ADC PARKS & GREENSPACE ARBORICULTURE

PLANNING APPLICATION: AW/354/14/T

ADDRESS: 10 Tithe Barn Close Aldwick PO21 4EY

BRIEF DESCRIPTION: Fell 1 No Ash tree & 1 No Tulip tree

TPO Plan

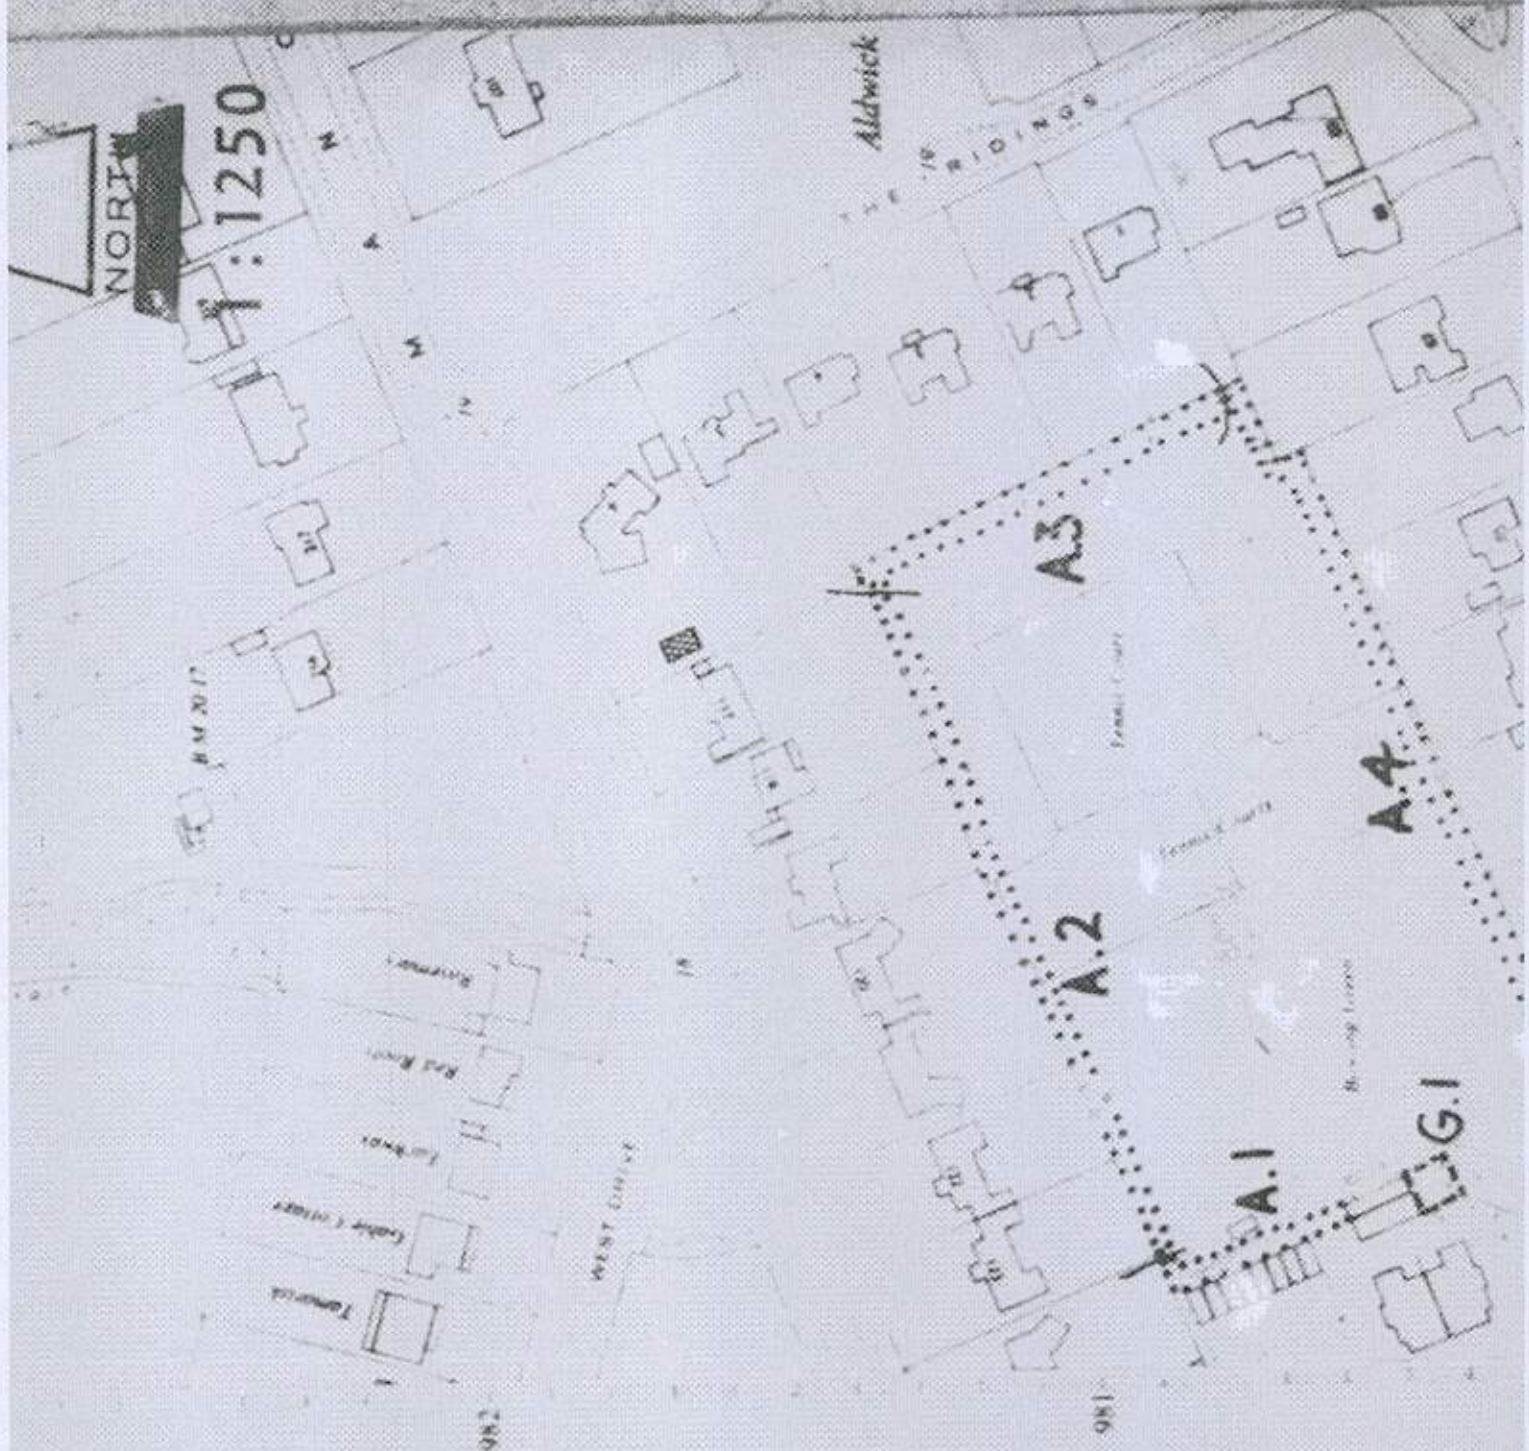
- The trees outlined in this application are situated along the southern boundary of 10 Tithe close.
- The applicant has requested the felling of **T1** and **T2**, having cited 'shading', not being visible from the 'main highway' and the fact there are other trees in the garden to help the amenity value of the area.

- **T1** and **T2** are both in good to fair overall condition. It is also from a visual inspection that both **T1** and **T2** have both had reductions. These do appear to have completed to a standard that would meet the criteria set by the BS 3998 Section 7- Pruning and related work. This does mean a reasonable amount of mass from the crown. Also the position of the final cuts appears to have met the standards as set by the BS 3998: Section 7.2.5 figure 2.

- As these trees have a good retention span (as **T1** and **T2** are semi mature), and both trees are good overall condition, it would be my recommendation that both **T1** and **T2** are given TPO orders.
